Our Case Number: ABP-314610-22

Re: BusConnects Ballymun/Finglas to City Centre Core Bus Corridor Scheme
Ballymun/Finglas to Dublin City Centre

BALLYMUN FINGLAS SCHEME no 314610

Drawing File Name: BCIDD-ROT-GEO\_GA-0304\_XX\_00-DR-CR-0020  
 Sheet Number: 20 of 37  
 Status: A  
 Rev: M01

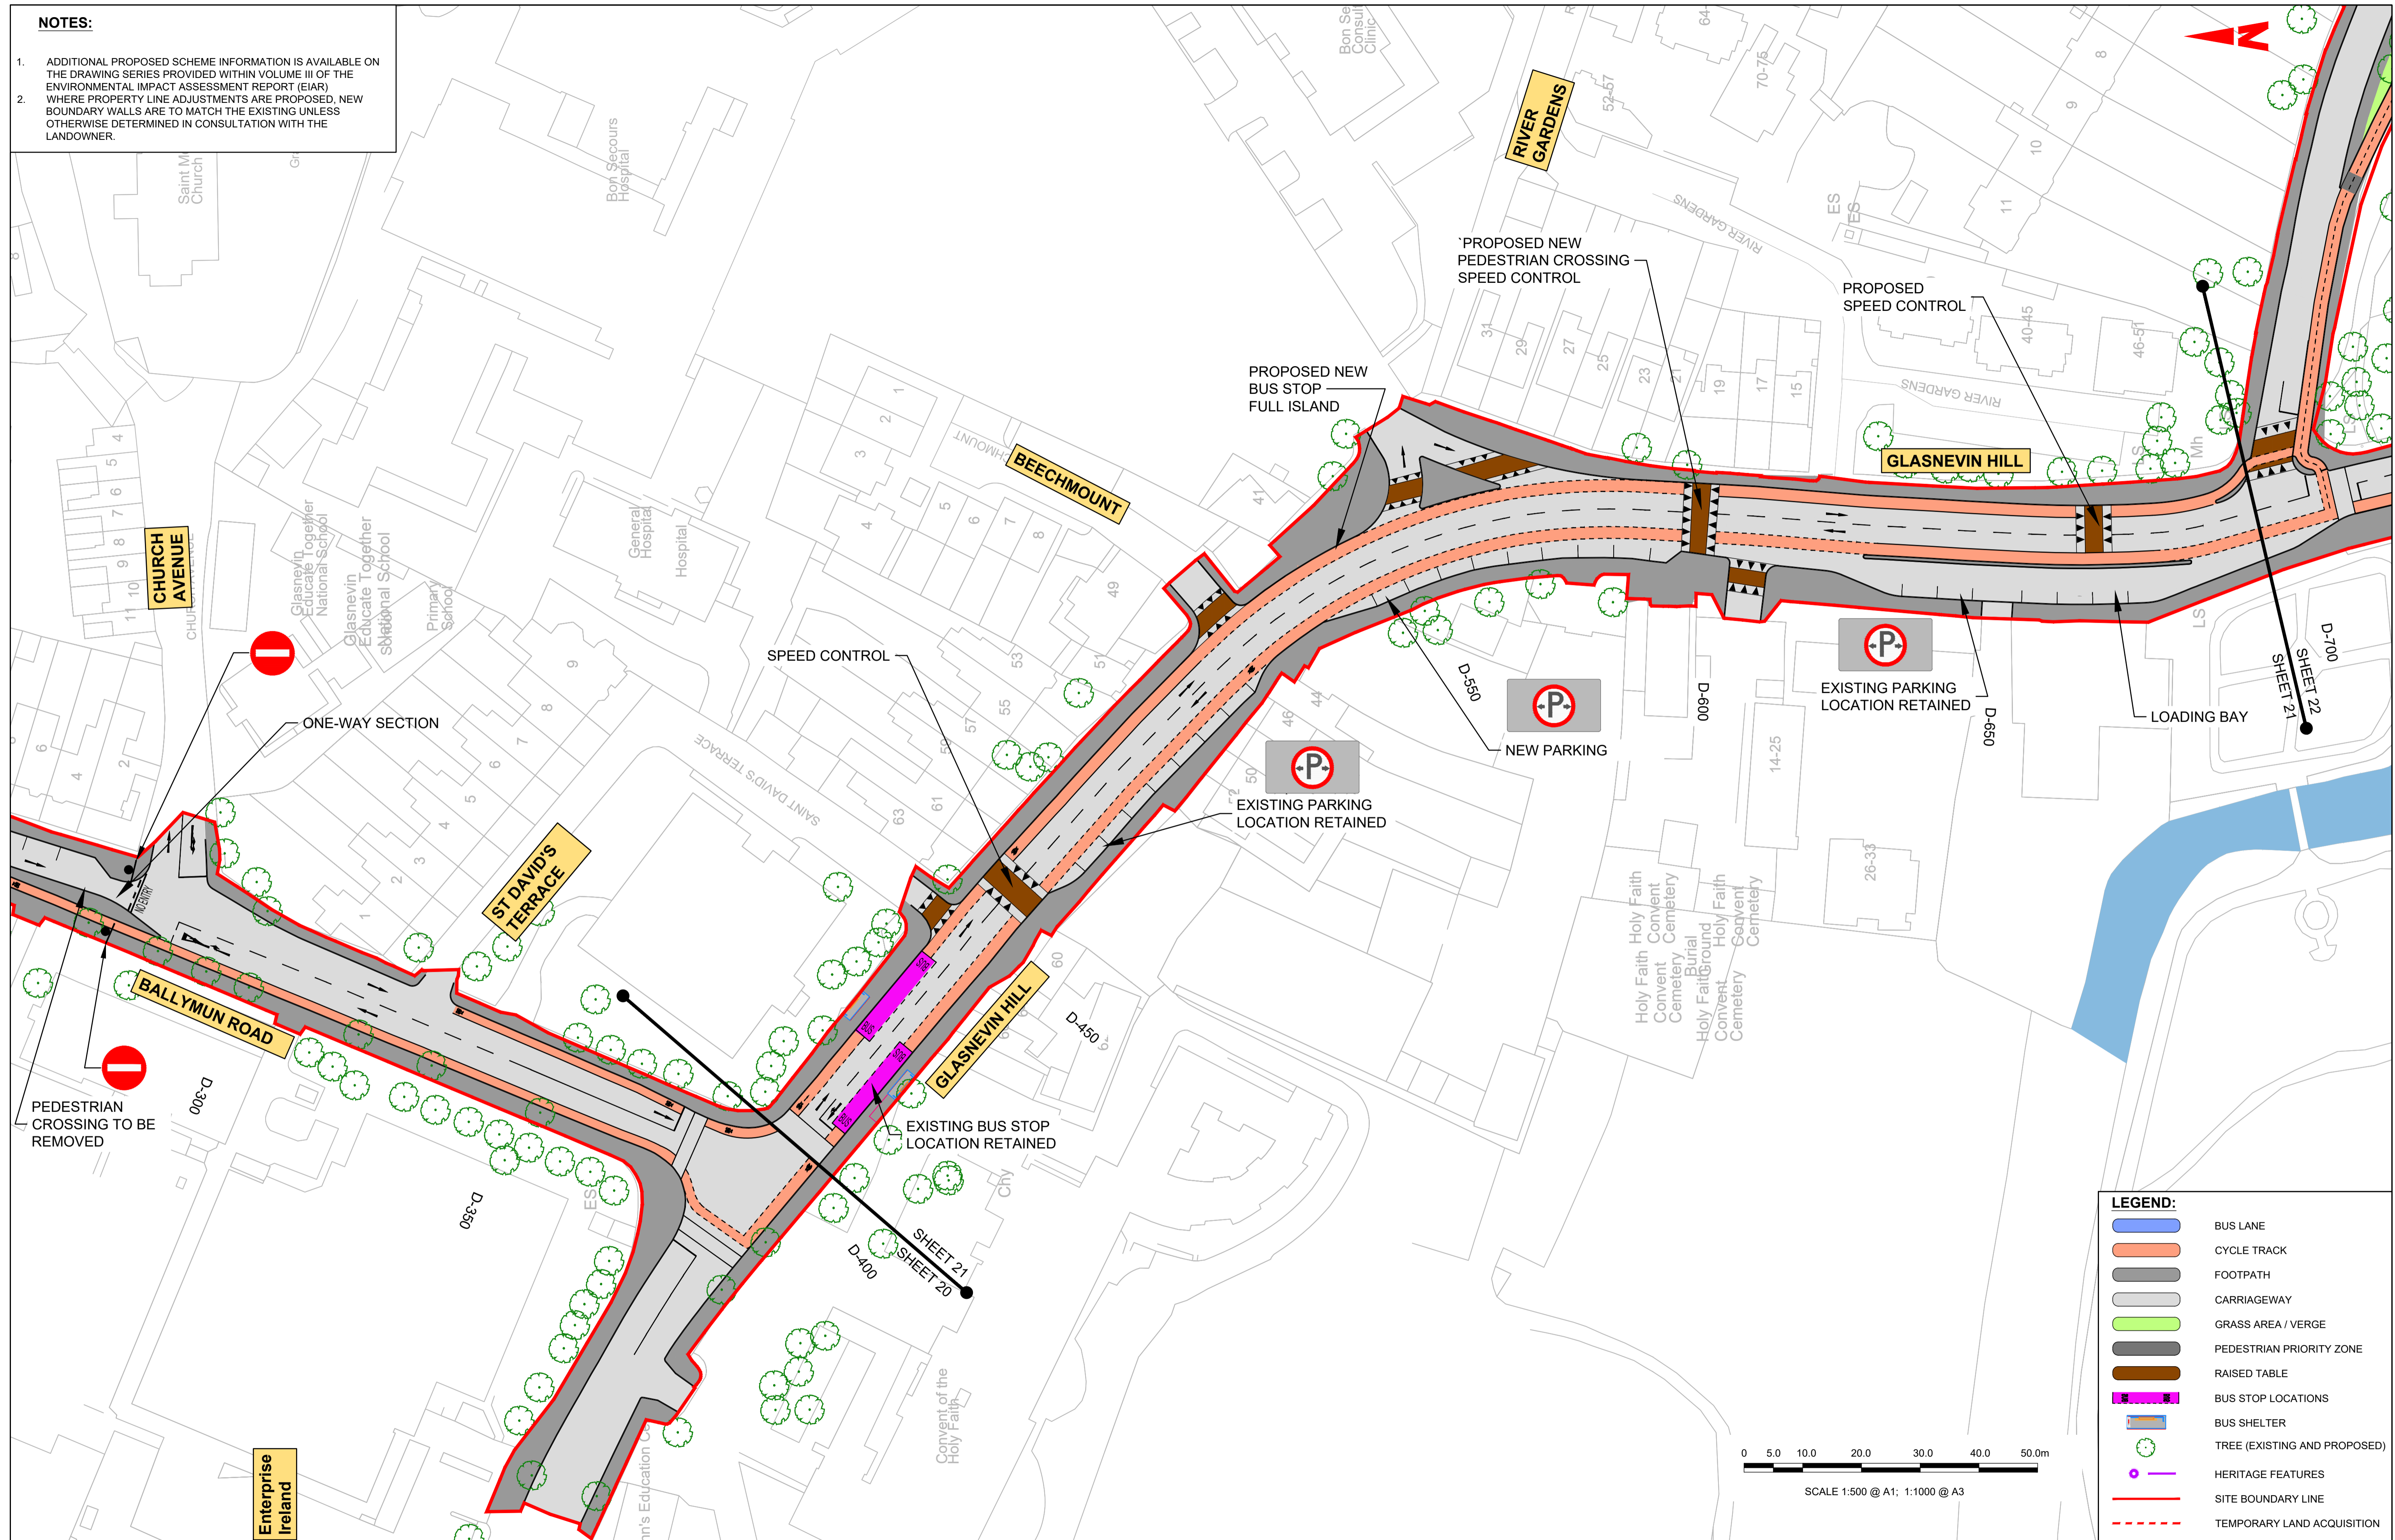
What seems far more problematic is the proposal illustrated on map 20 to make a section of Ballymun Road adjacent to Church Avenue one way. If I am correct in my interpretation of the arrangements on Mobhi Road, the only inconvenience to residents on that section of Ballymun Road is that they will have all the outbound traffic in the evening peak; this is an inconvenience suffered by many city residents in either the morning or evening peak. Indeed some of them will find this 24/7 one way causes issues for them.

The suggested route northbound to get from Botanic Road to the top of Mobhi Road adds considerable length to the journey which clearly gives rise to much greater fuel consumption. Environmentally this proposal seems completely nuts. Therefore I think it should not be permitted.
